Application No: A/82/20/HH
Site Address: Harcourt West Drive Angmering BN16 4JE
Description of works: Extend domestic single storey garage and single storey enclosure to existing pool.

Thank you for your internet representation made on 2nd July 2020 which has been recorded as an objection with the comments as follows:

<table><tr><td>PROJECT HARCOURT West Drive. Angmering Littlehampton. BN16 4JE</td><td colspan="3"></td></tr><tr><td>DRAWING PROPOSED PLAN and ELEVATIONS</td><td colspan="3"></td></tr></table>

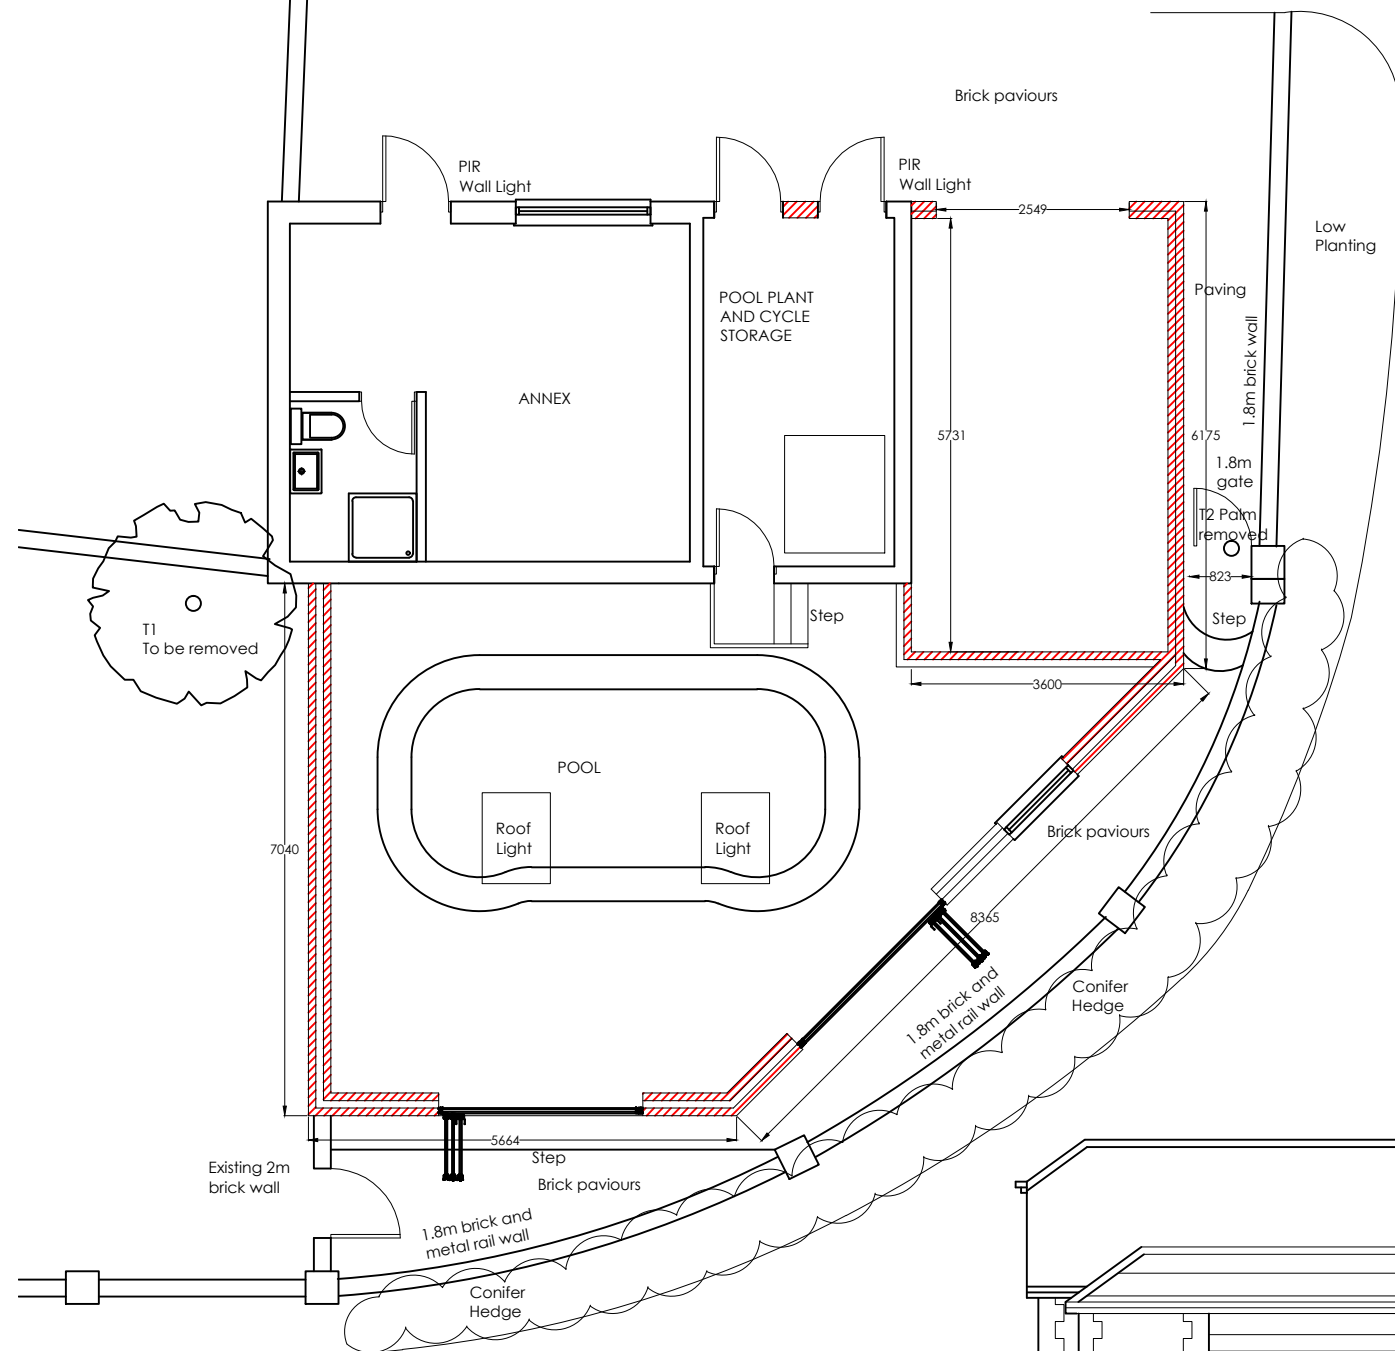
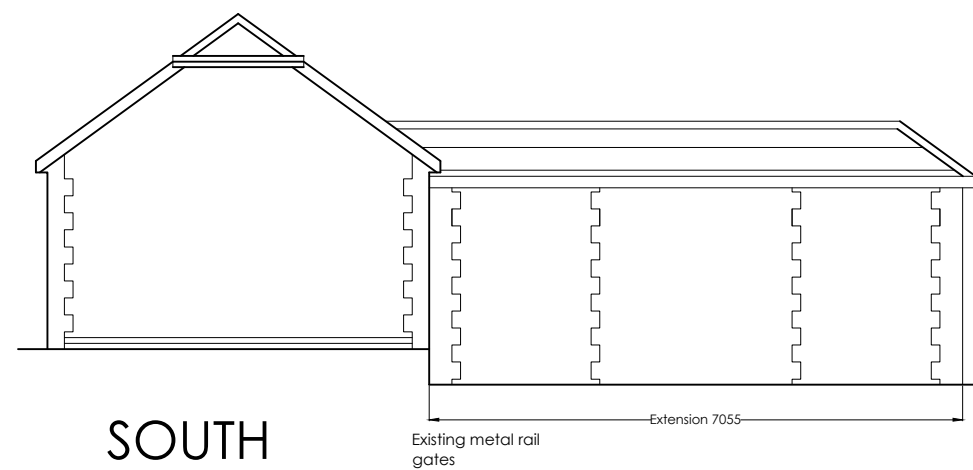
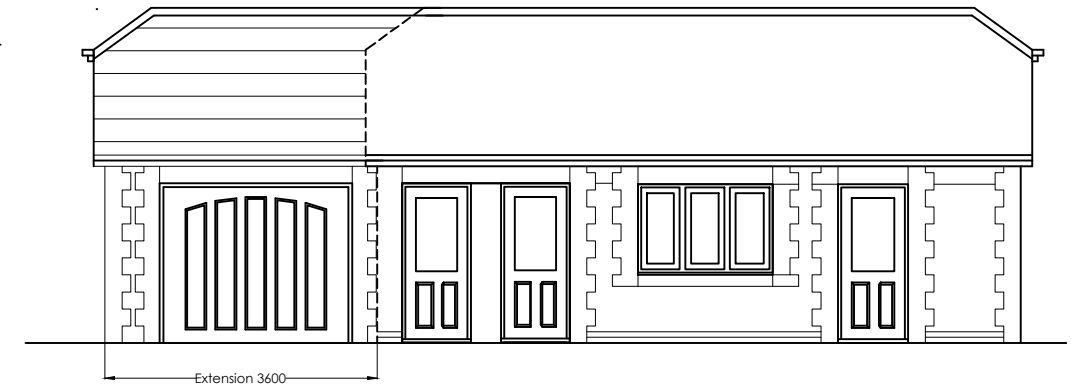
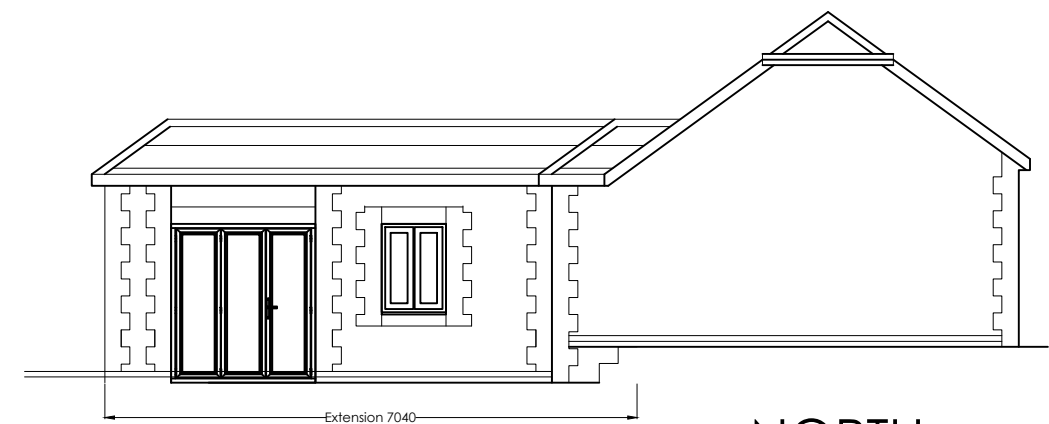
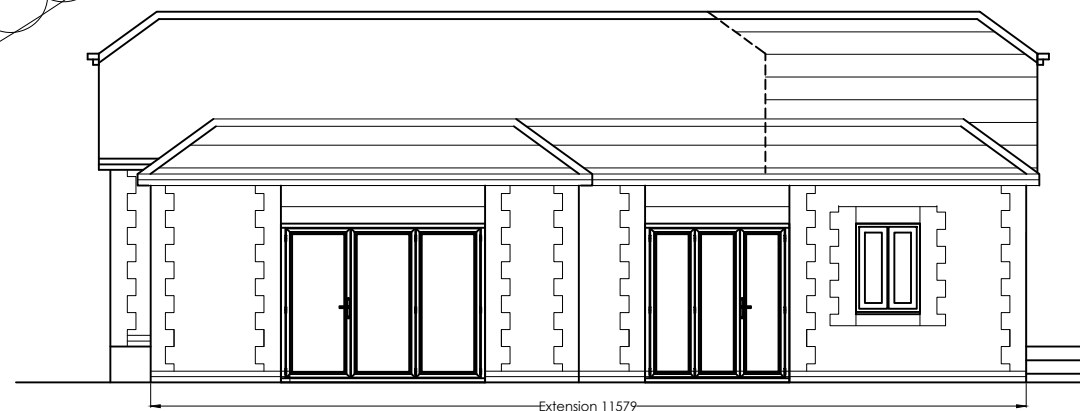
The committee considered that the proposal would result in a substantial building extension too close to the road which would be detrimental to the street scene and be out of keeping with other properties in the area. The APC therefore object on the following grounds - Design and external appearance, impact on the surrounding area and effect on neighboring occupiers.
